Please ask for: Nicola Moore
Email: nicola.moore@arun.gov.uk
Telephone: Ext 37944
Our Ref: AW/152/20/CLP
Your Ref:
Date: 1st July 2020

Lawful Development Certificate for a Proposed Use or Development

Development: Lawful development certificate to extend existing 1st floor dormer.
Location: 17 Stapleton Court Aldwick PO21 4BH

REAR ELEVATION

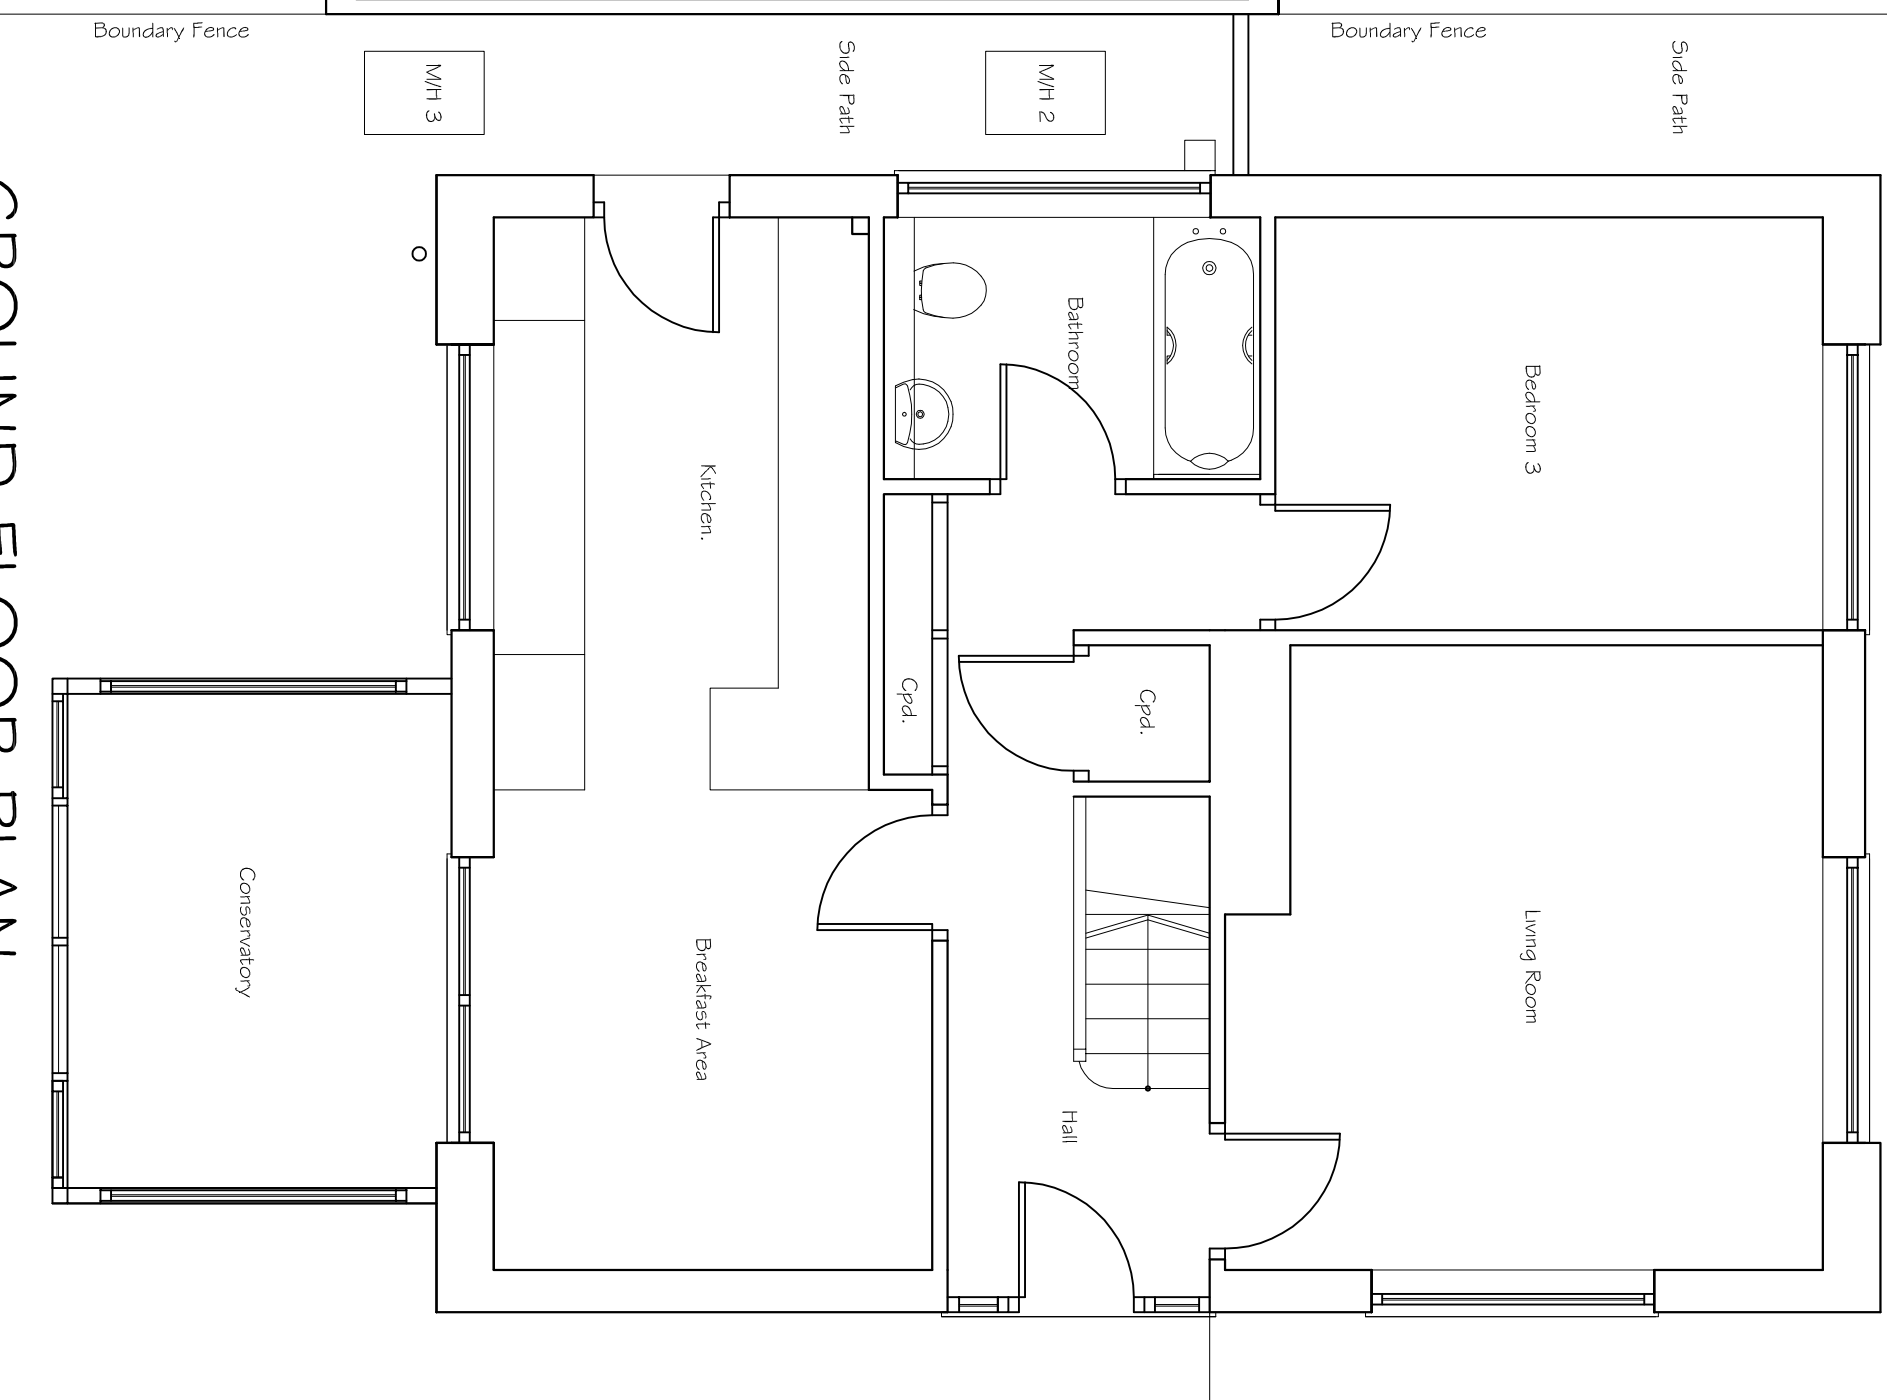
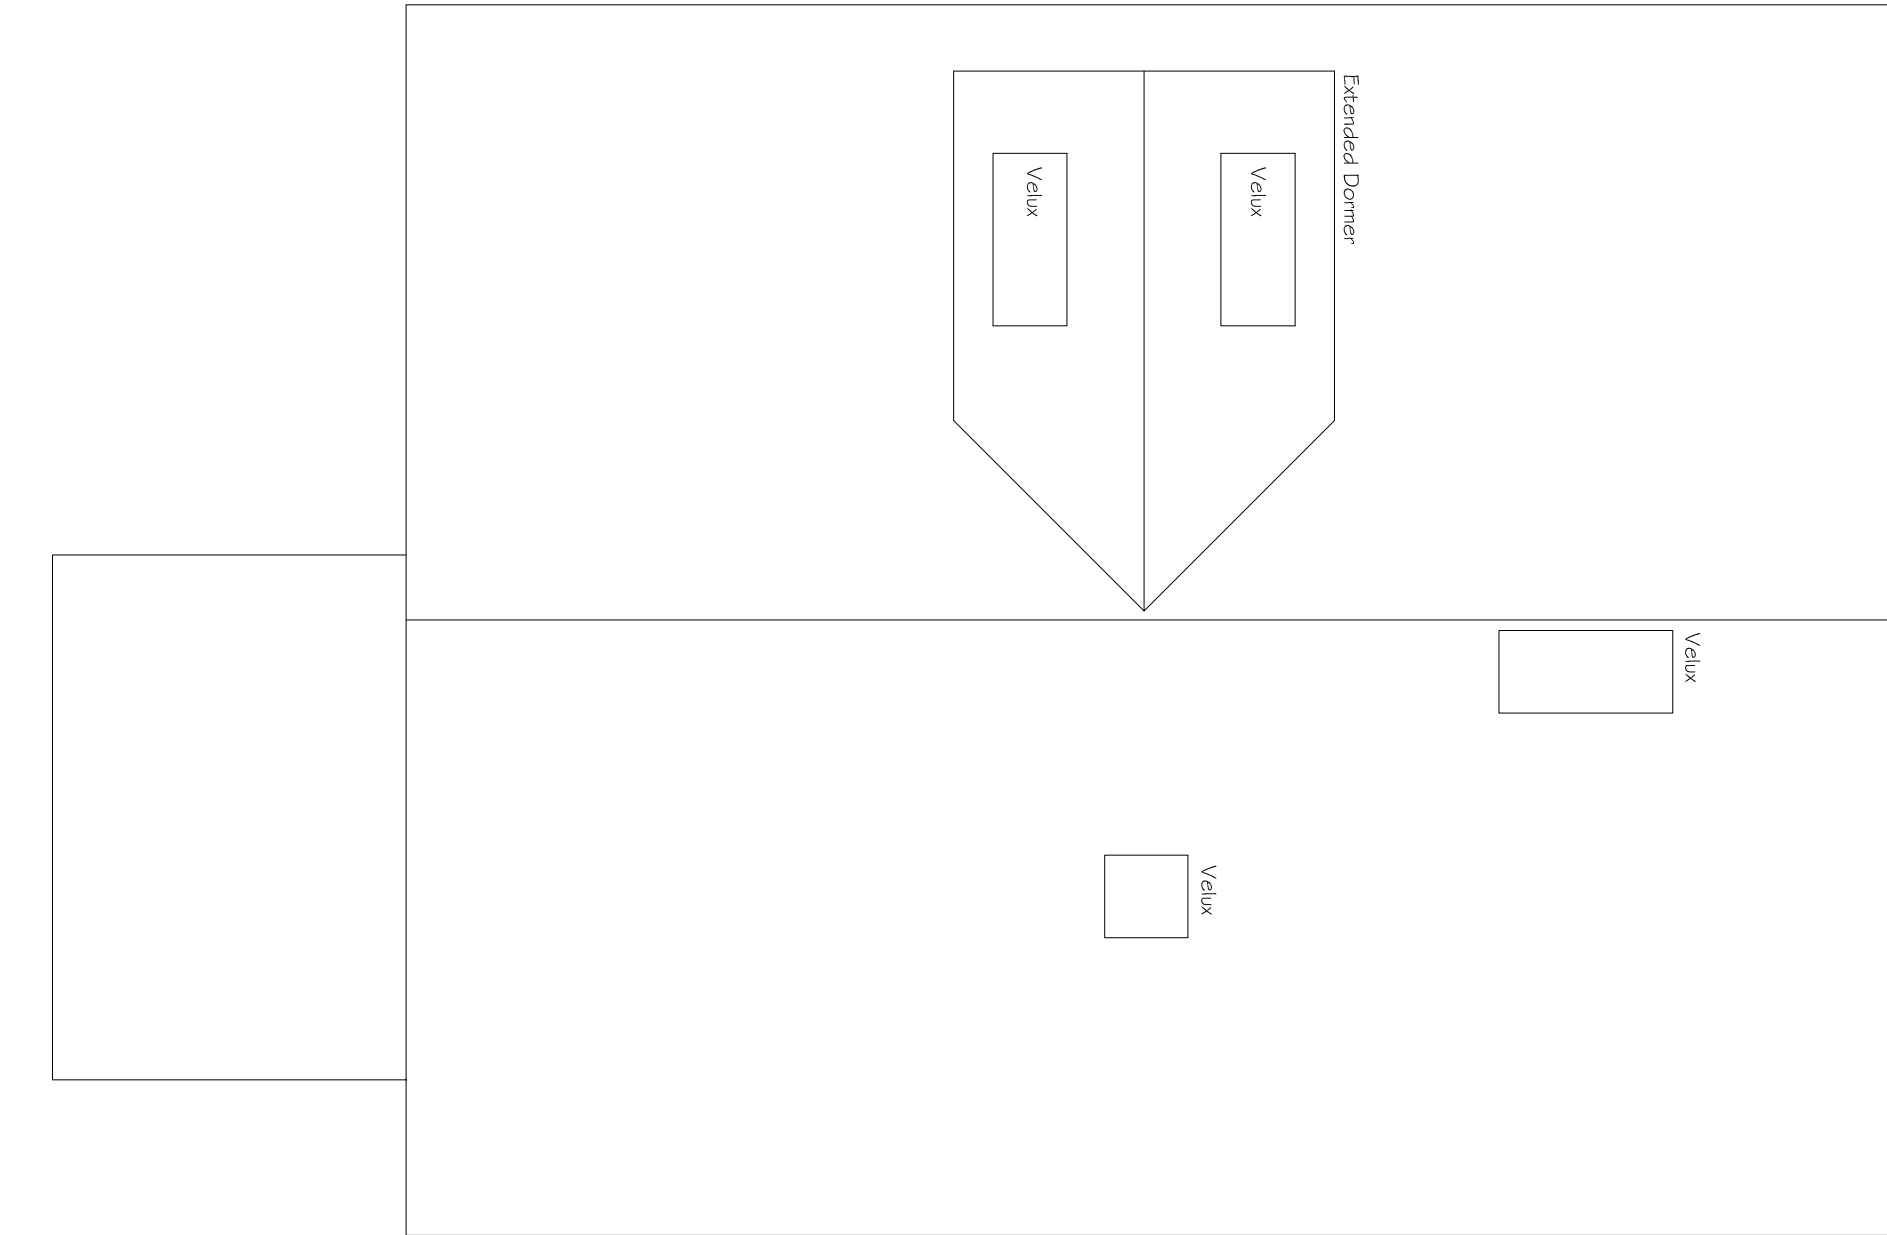
On checking the measurements, the first floor rear elevation window measures 1.8m at a scale of 1:50 on the floor plan, but 1.4m at a scale of 1:100 on the proposed elevation. Please check the measurements and amend accordingly.

SITE PLAN scale 1 : 500

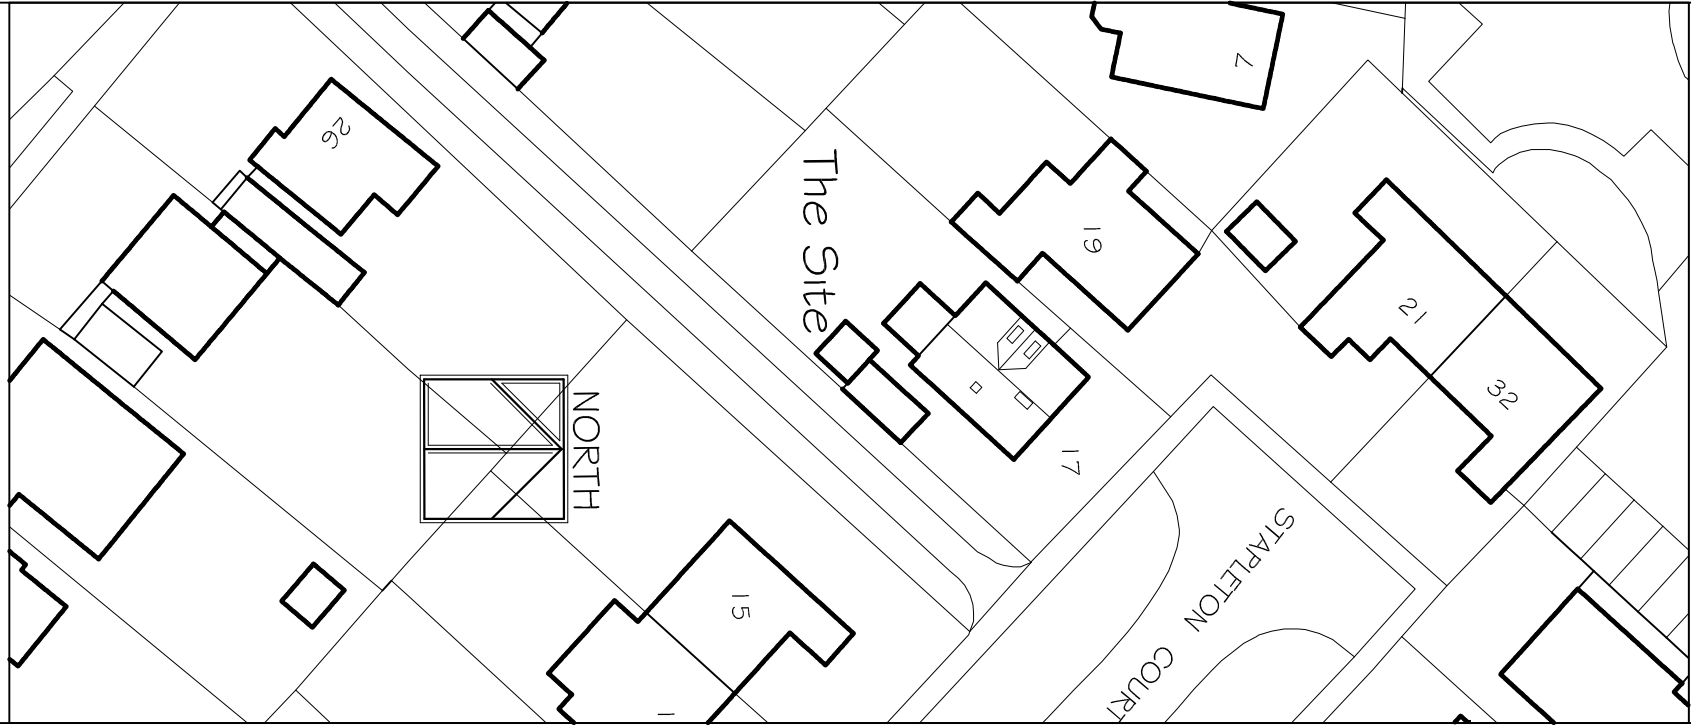
The red edge is not clear on the Location Plan, please amend and re submit.
